CITY OF ALBUQUERQUE

Re: Self Storage Building Addition
5310 San Mateo Blvd. NE
Traffic Circulation Layout
Architect's Stamp 10-13-16 (F18-D059)

**C2**  
 10/26/2016

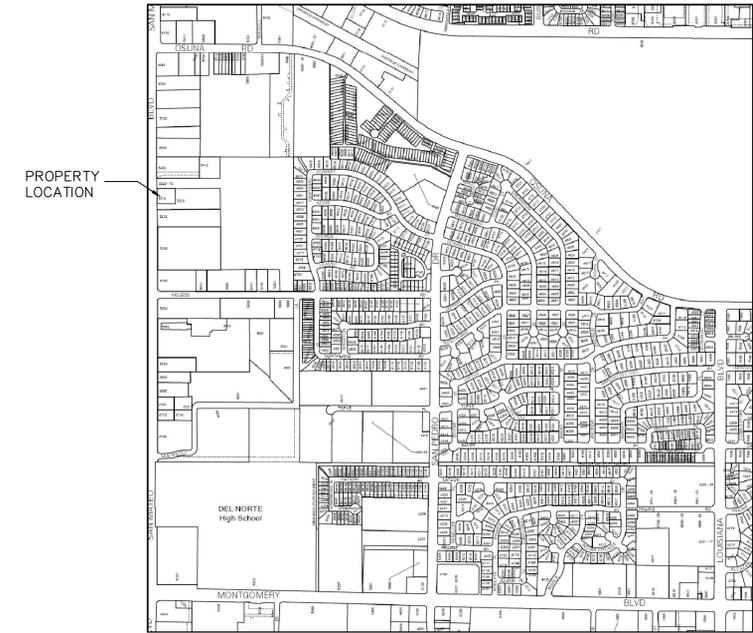
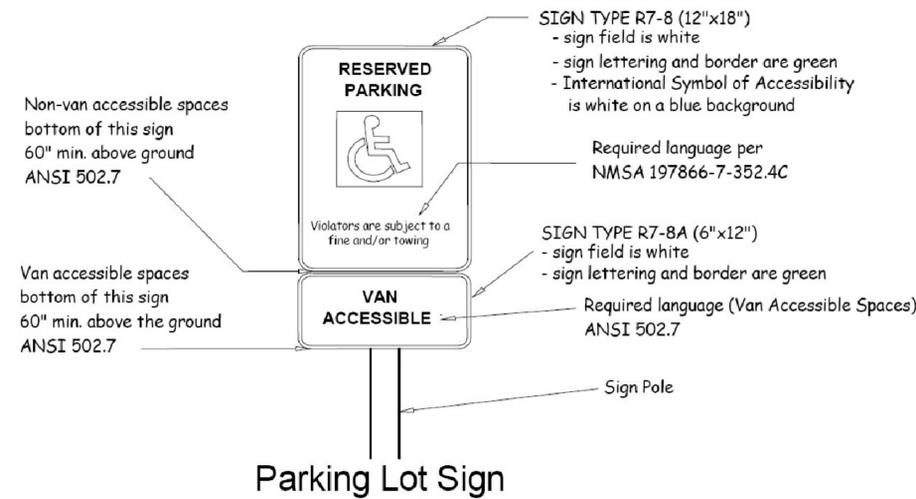
1. Clarify the number of parking spaces required by the zoning code.
2. The ADA accessible parking sign must have the required language per 66-7-352.4C NMSA 1978 **"Violators Are Subject to a Fine and/or Towing."** Please call out detail and location of HC signs.

3. The ADA access aisles shall have the words **"NO PARKING"** in capital letters, each of which shall be at least one foot high and at least two inches wide, placed at the rear of the parking space so as to be close to where an adjacent vehicle's rear tire would be placed. (66-1-4.1.B NMSA 1978)

4. Install an ADA curb ramp with detectable warning surface (truncated domes) at the corner. Add note: "Detectable warning surface shall be cast in place replaceable"

5. Change parking on North West side of the site to head-in parking.
6. Close one driveway curb cut.
7. Remove driveway on corner, unused curb cuts must be replaced with sidewalk and curb & gutter. A build note must be provided referring to the appropriate City Standard drawing.

8. Add a note stating "All broken or cracked sidewalk must be replaced with sidewalk and curb & gutter." A build note must be provided referring to the appropriate City Standard drawing.
